Application for Planning Permission for Works or Extension to a Dwelling

Development: Erection of single storey rear extension and front porch extension following the demolition of existing front porch and detached rear shed/store
Location: 5 Pearson Road Arundel BN18 9HP

I regret that I am unable to accept your documents as a valid application until the following item(s) have been received or resolved :-

Title
BLOCK PLAN

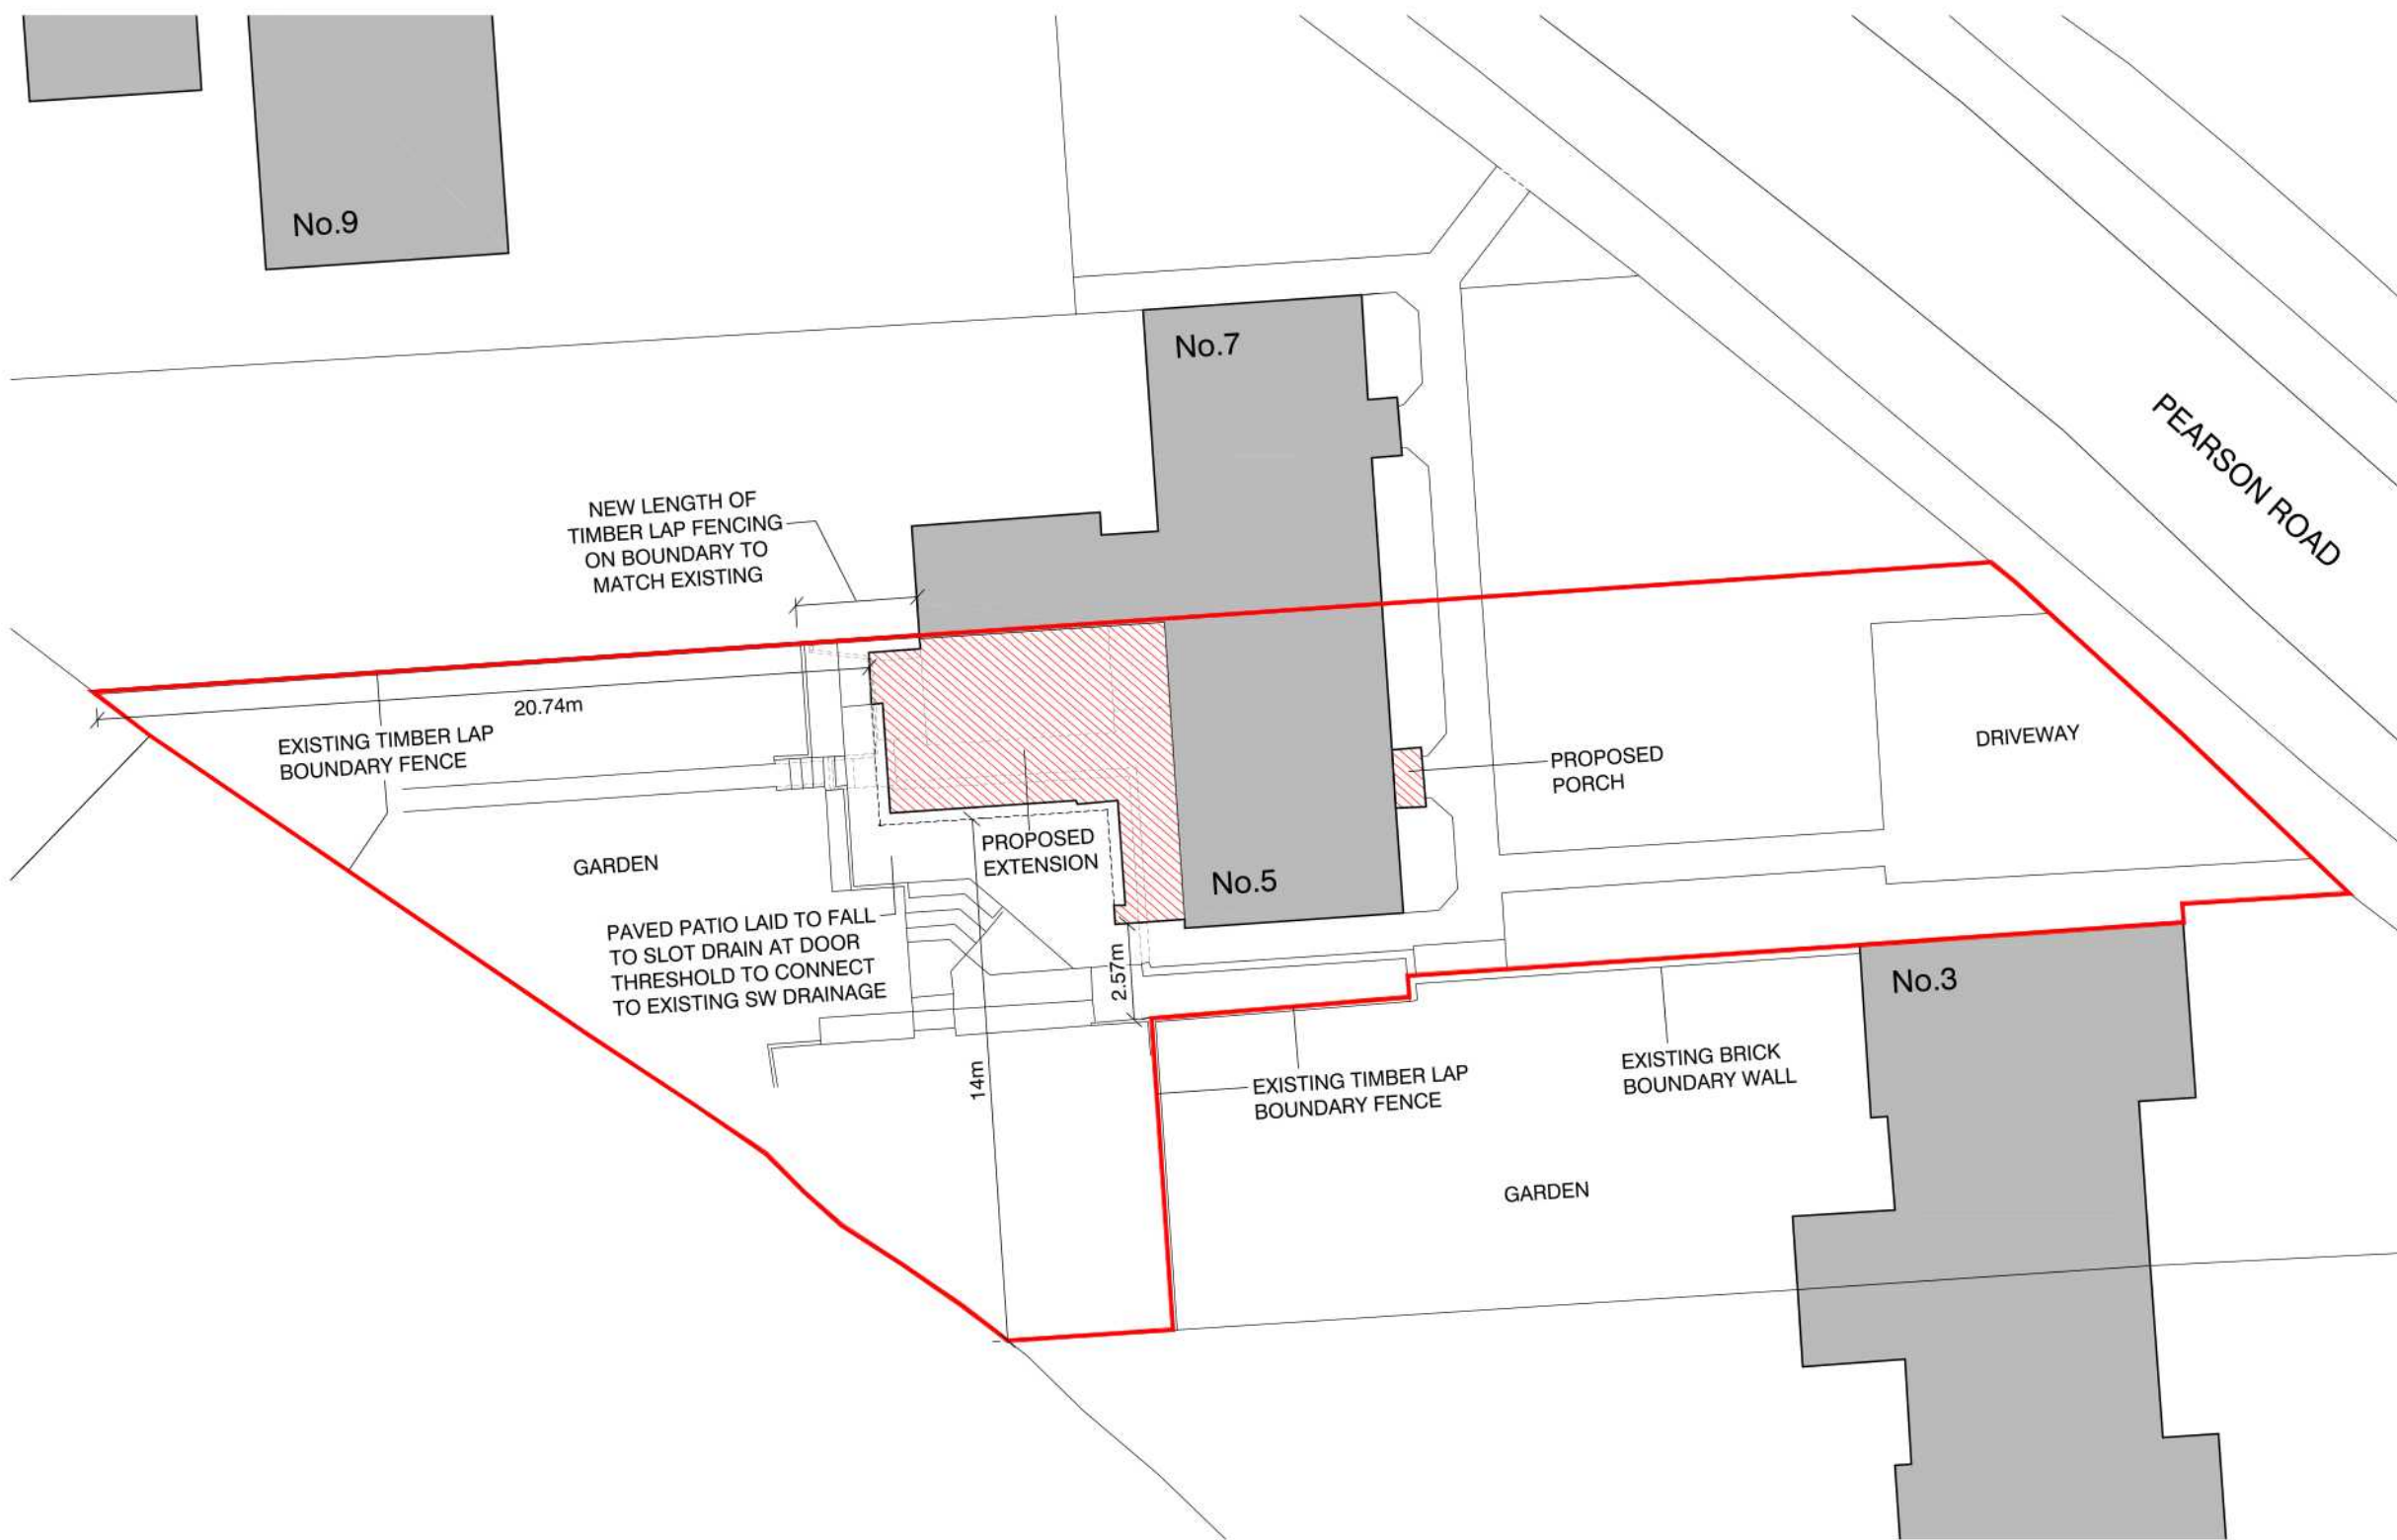
Block Plan

Please add the dimension from the proposed extension to the rear boundary. Further details of what must be included on the plan can be found in the Validation Requirements List.
